**Sent:** 11 December 2025 16:29  
**To:** DC Admin  
**Subject:** FW: Planning Applications 2025/61/92713/E- Consultation Response - Ref 46/96

Please see attached email I am forwarding to you as I have had no response from Hazel Irving, Kirklees Tree Responding Officer. I am concerned my email may have not been delivered to her and as today is the closing date for comments to be registered against the planning application for the site at 27-43 Moor Lane, Gomersal, BD19 4LF, I am registering this objection with you. The plans for both planning applications for this site are showing the TPO trees mentioned below, incorrectly.

Re: Planning Applications 2025/61/92713/E

I have reviewed the AMS which has been submitted Ref. 220218b, dated 10.11.2025 that you have based your decision on, this is not showing the trees in our garden correctly classified and they are not in the correct location. The last page of the AMS Ref 220218b prepared by James Royston Tree Protection Plan to BS5837:2012 at Moor Lane, Gomersal is showing our trees referenced as G17. These trees are located in our back garden at 21 Summerdale, Gomersal, Cleckheaton, BD19 4AH. On this plan G17 is showing 4 trees, ther

Appendix 2: Draft tree protection plan

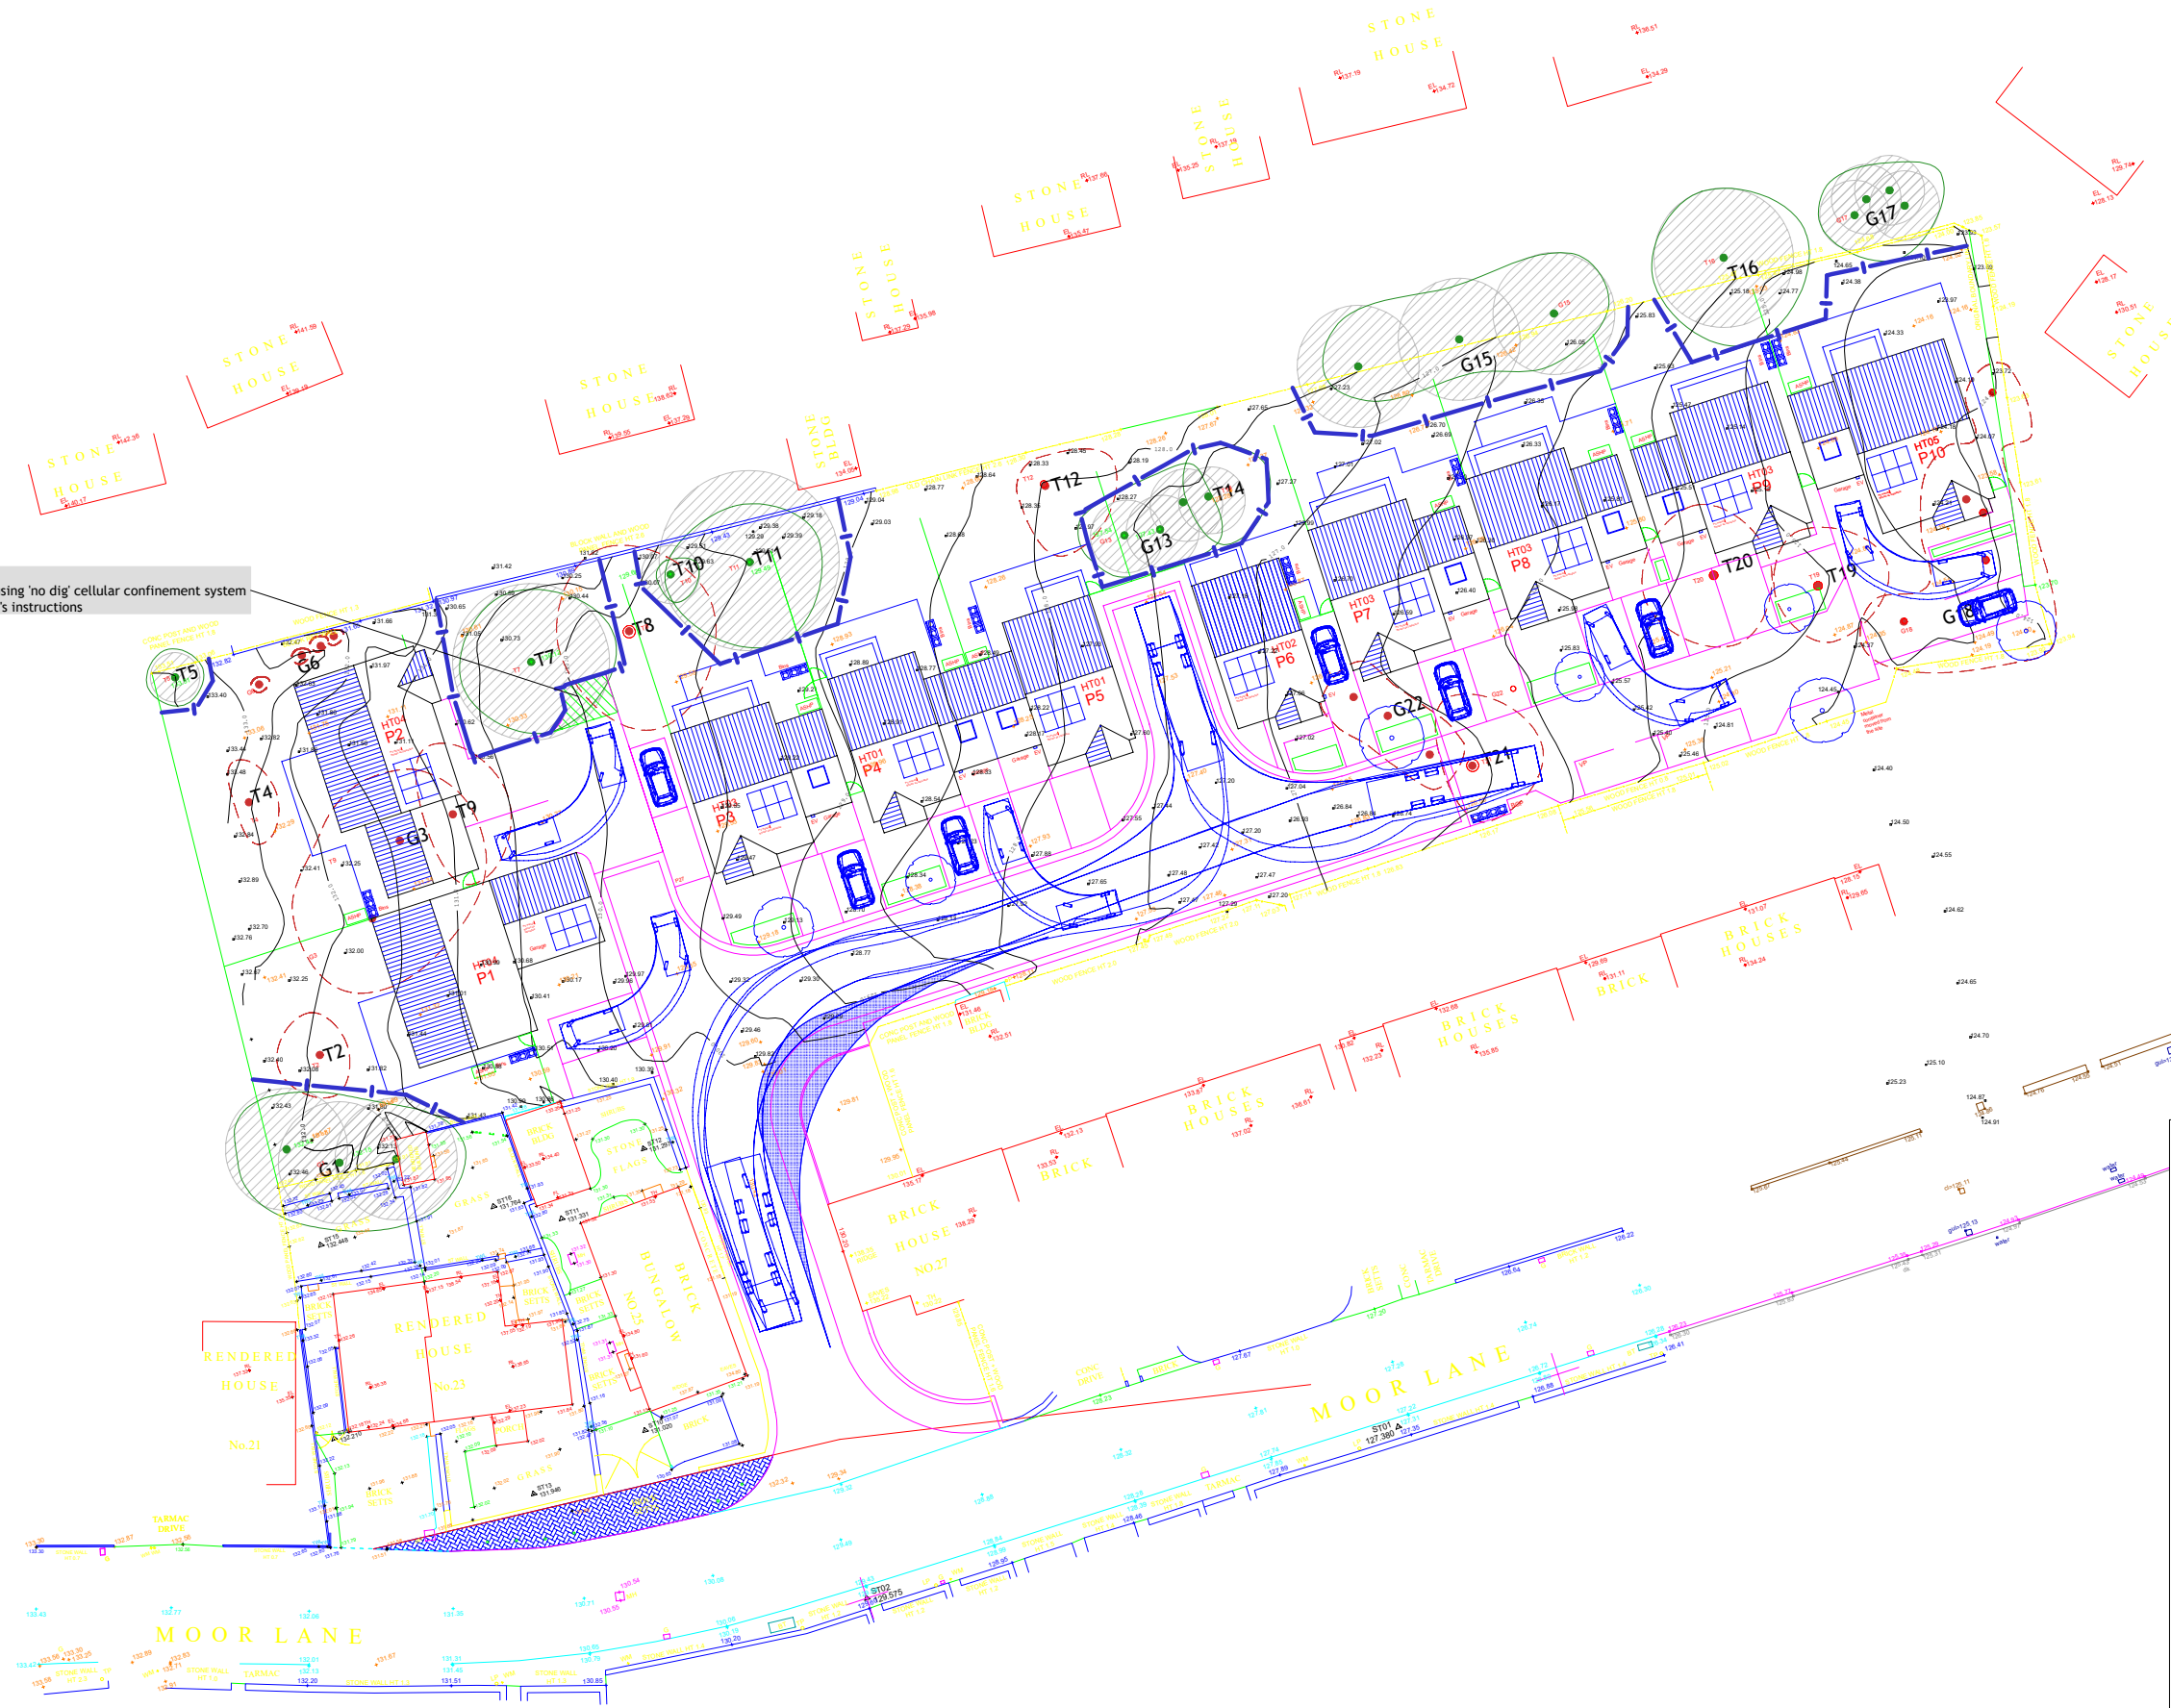
I have now, because of this anomaly, looked at other plans on both applications (2025/44/92737 and 2025/61/92713) for this site and **all** the plans seems to be showing our trees incorrectly classified as G17 and the wrong number of trees shown. Do these plans need amending?

Appendix 5: Tree protection plans

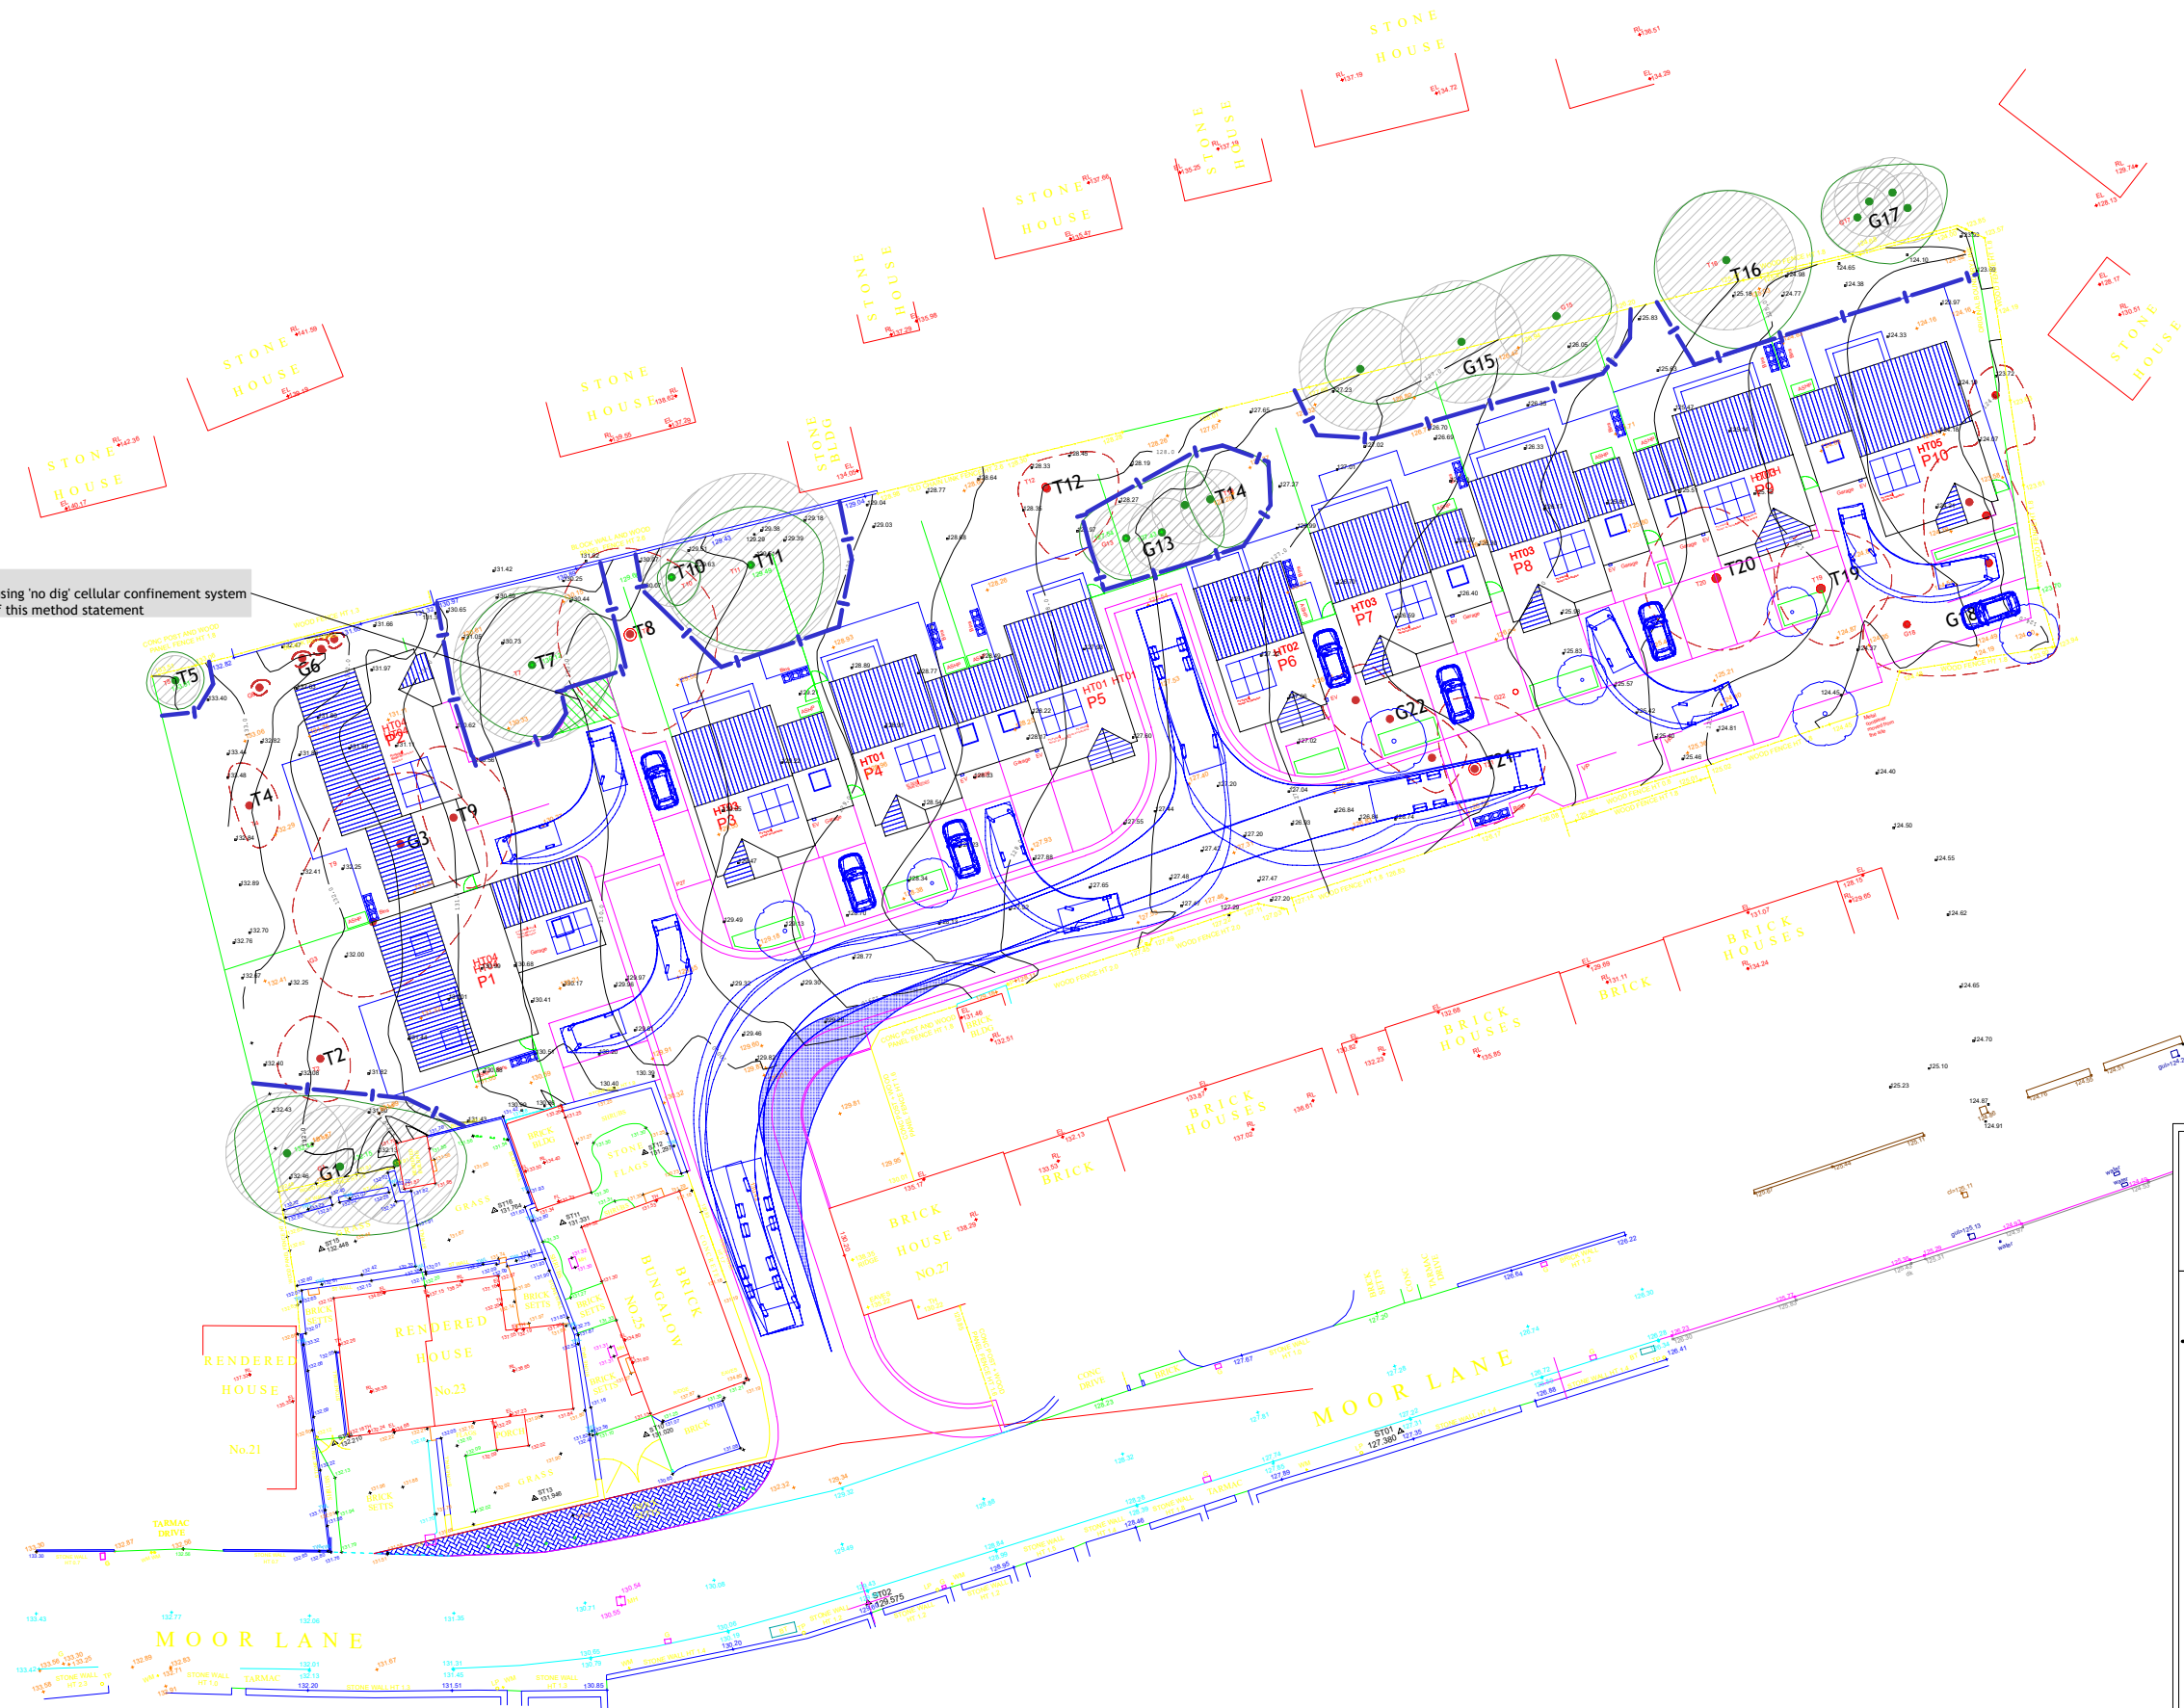
The location of the trees appears to be incorrect and the size they are depicted as is far too small. Some of these 8 trees are as big and tall as the tree marked T16 on these plans.

I have measured the correct distances of the 8 trees and here are those details:

Distance of nearest tree from 21 Summerdale garage 11.5 metres

Distance from the western boundary 2.7 metres

Distances from the wooden boundary fence in 21 Summerdale's garden, the 2 nearest trees to this boundary are 36 centimetres and 28 centimetres

I am concerned this development does not appear to be protecting the root ball of these TPO trees as adequately as it should, when compared to the other trees on the plan, a few metres away further west.
